April 9, 2020

City of Albuquerque
Development Review Board

**RE: PR-2019-002333 - Site Plan Review Request 5512 Buglo Ave. NW
Supplemental Information Submittal**

To whom it may concern,
Attached is our response to comments received at the February 26th and supplemental project DRB meetings for this case. The comments are addressed as follows:

City Project No. PR-2019-2333Zone Map No. B-11-ZSheet 1BOf 5

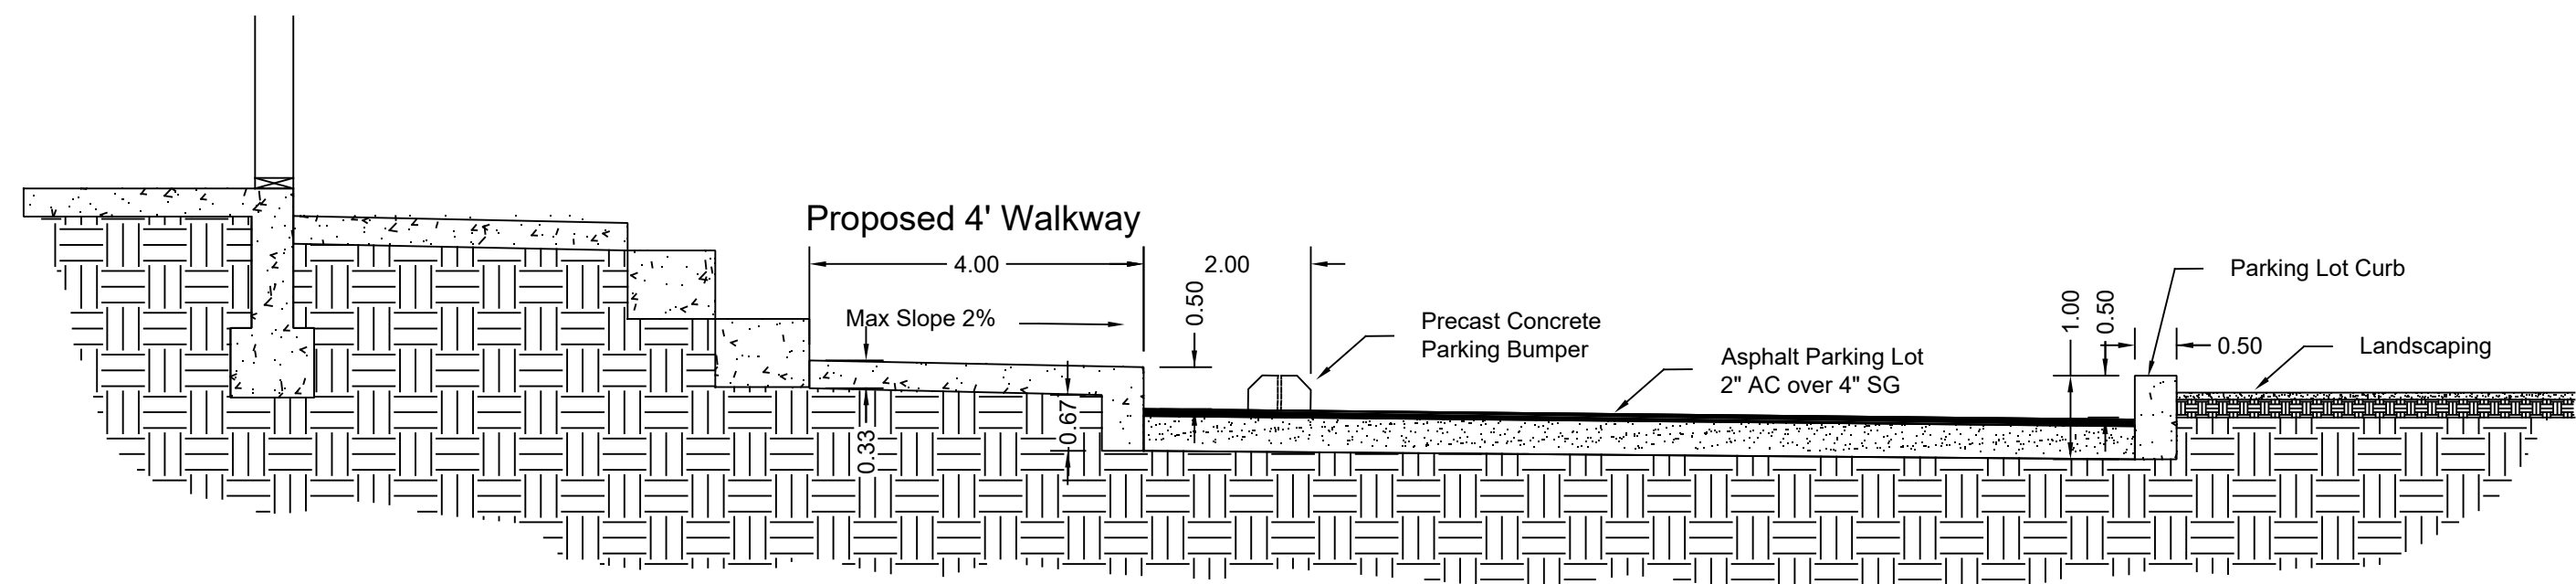
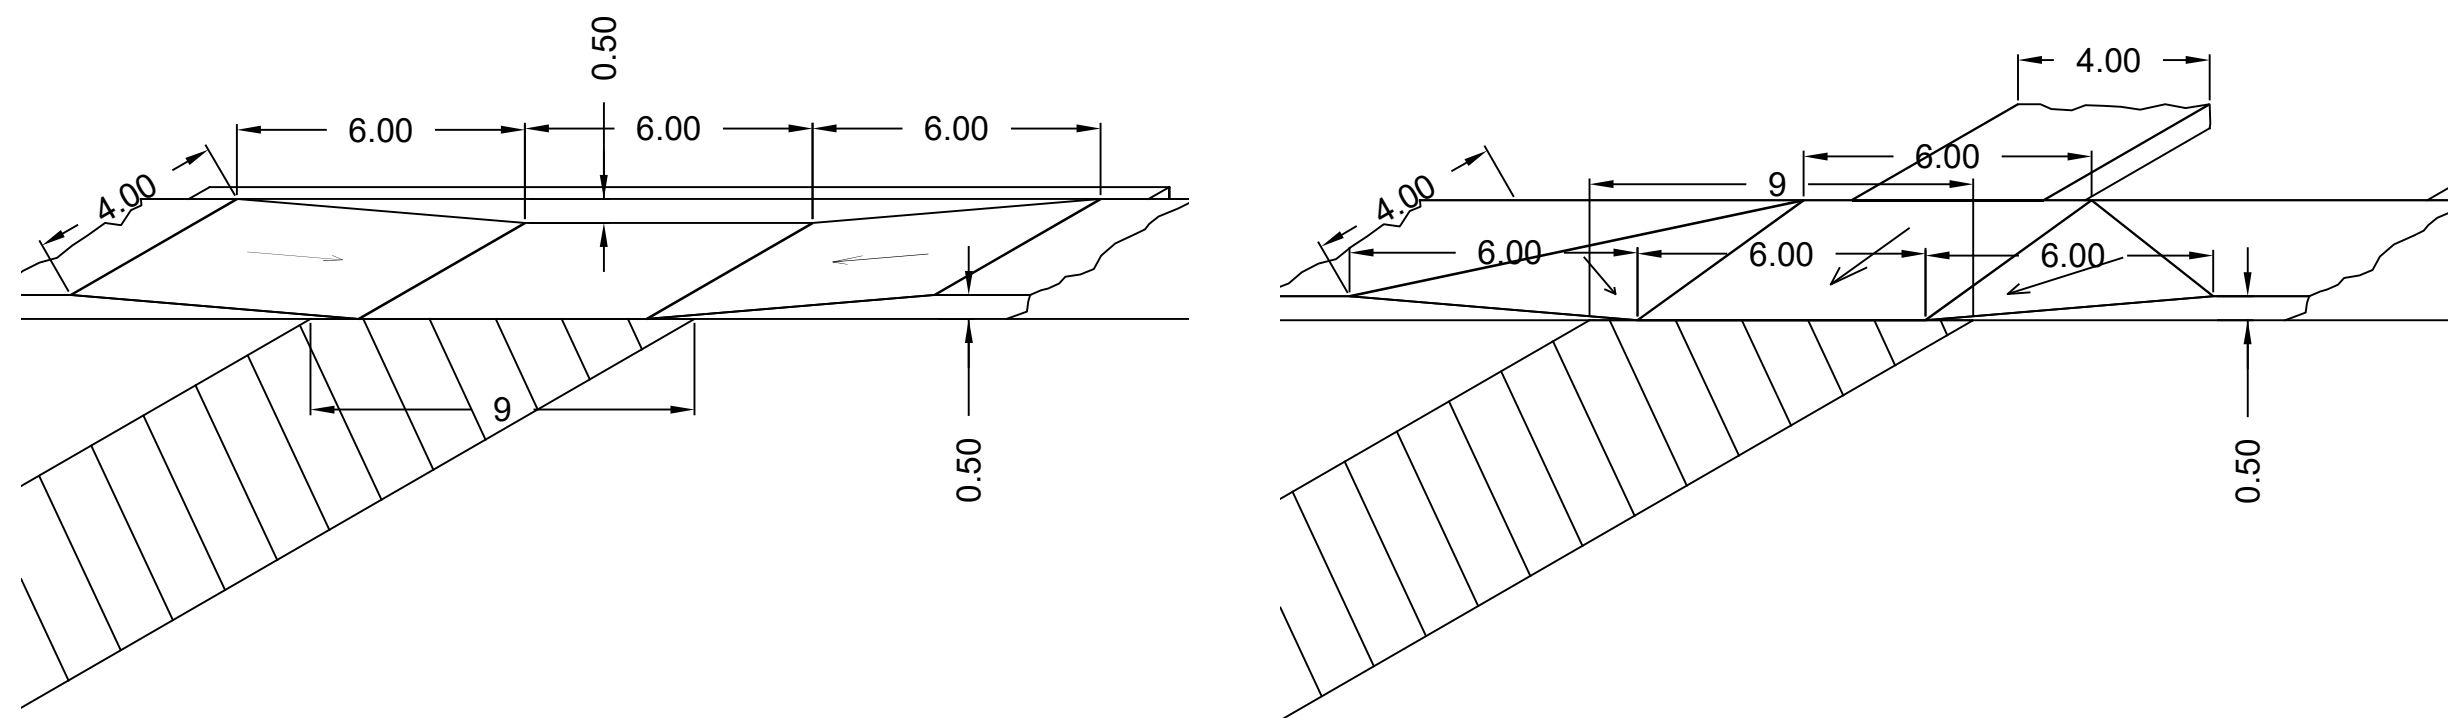
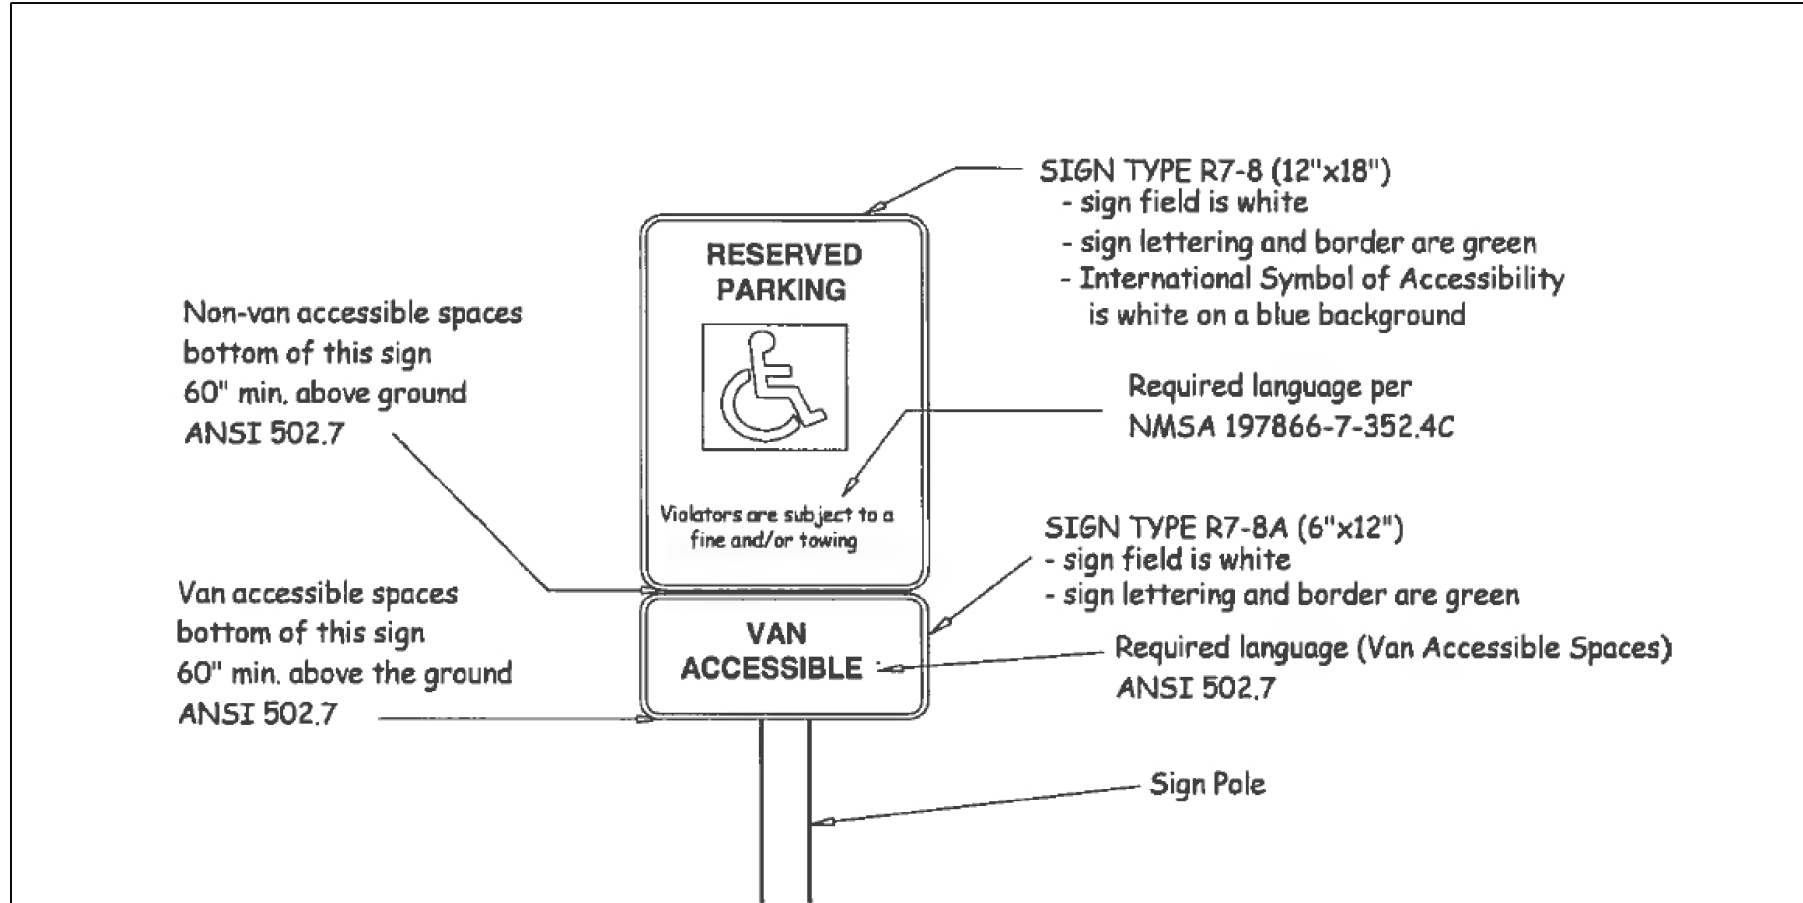
Previous Comments not marked off

1. Parking and open space calculations are presented on the Site Plan.
3. Three Bicycle parking facilities are provided and shown on the SHEET 1A Site Plan. A detail of the proposed bicycle racks is shown on the SHEET 1B Site Plan.
5. Mature trees must be removed due to the size requirements of the pond.
6. All three lots are to be combined into one lot so there will not be a need for connections to adjacent properties.

Drawing file: PR-209-002333_Apr_15_2020 (Supp - Landscape Plan) / SHEET 2 LANDSCAPING PLAN.pdf

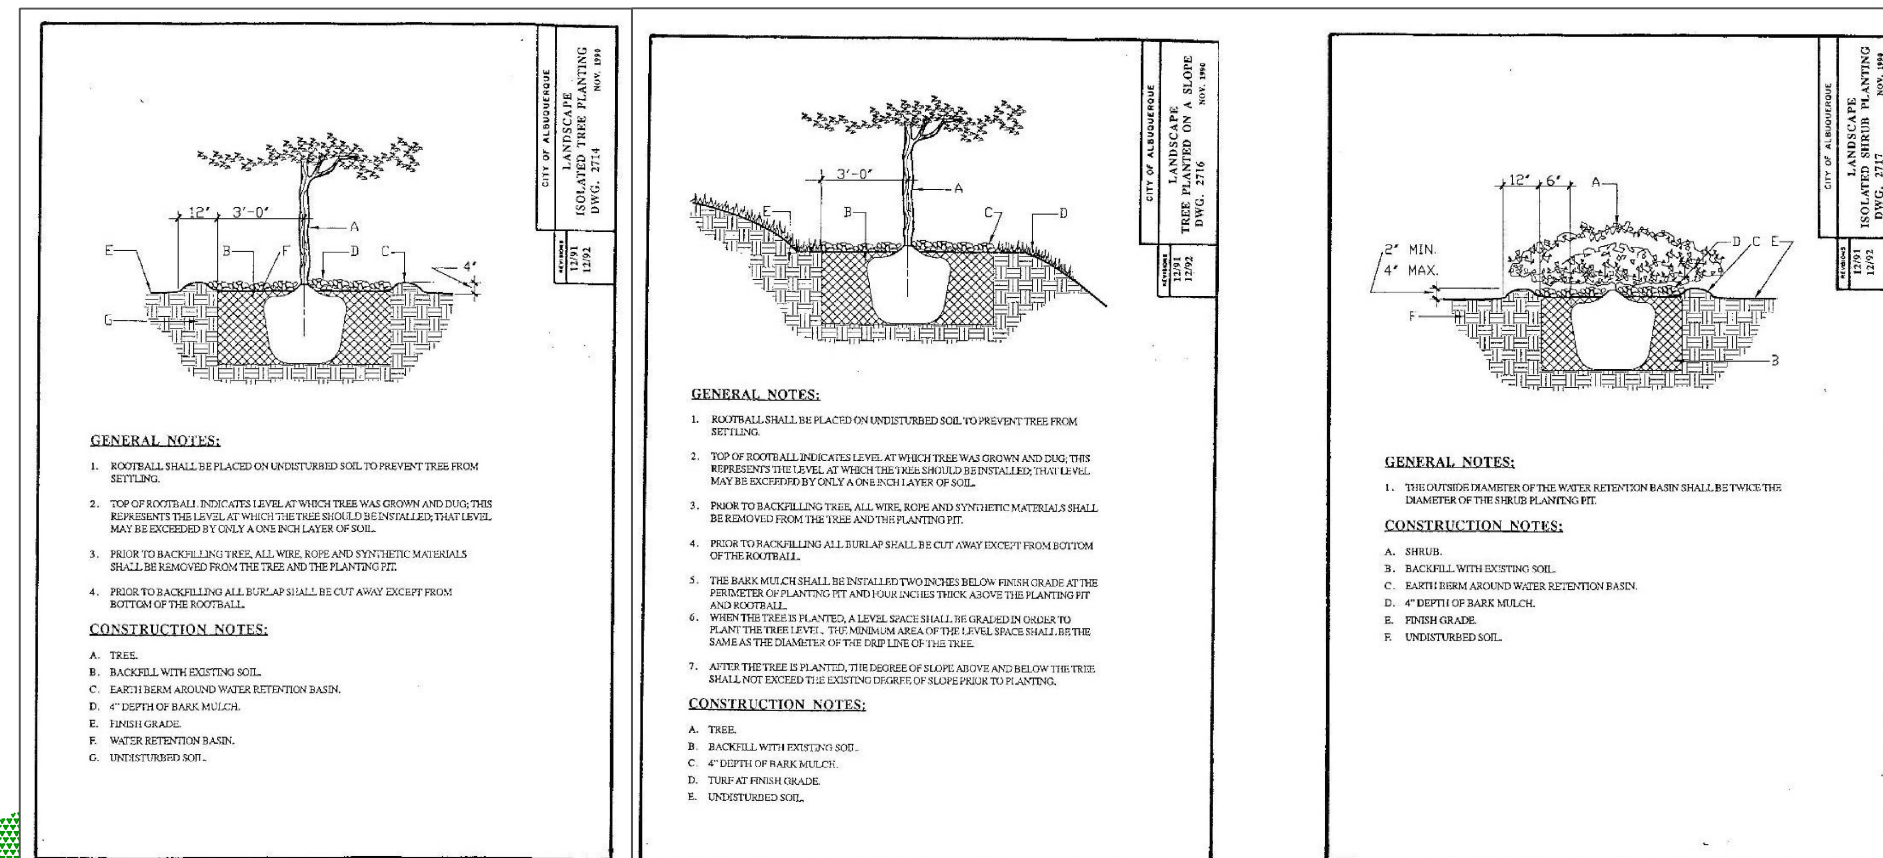
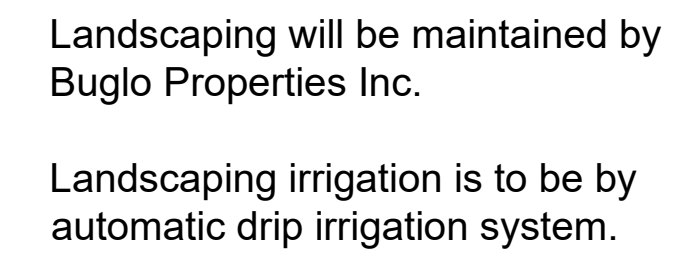
Comments added 2-24-20

1. Plant selections are from the Official Albuquerque Plant Palette. Plant species and proposed numbers are shown in the calculation tables presented on SHEET 5 LANDSCAPING PLAN.
2. The site does not contain rock outcrop. However there is exposed surface rock on site. The area where surface rock is exposed has been added to SHEET 5 LANDSCAPING PLAN. Photos of the surface rock are attached.
3. Wall regulations have been reviewed and requirements added to the plan.
4. Noted and will be considered.
5. Noted and will be implemented.
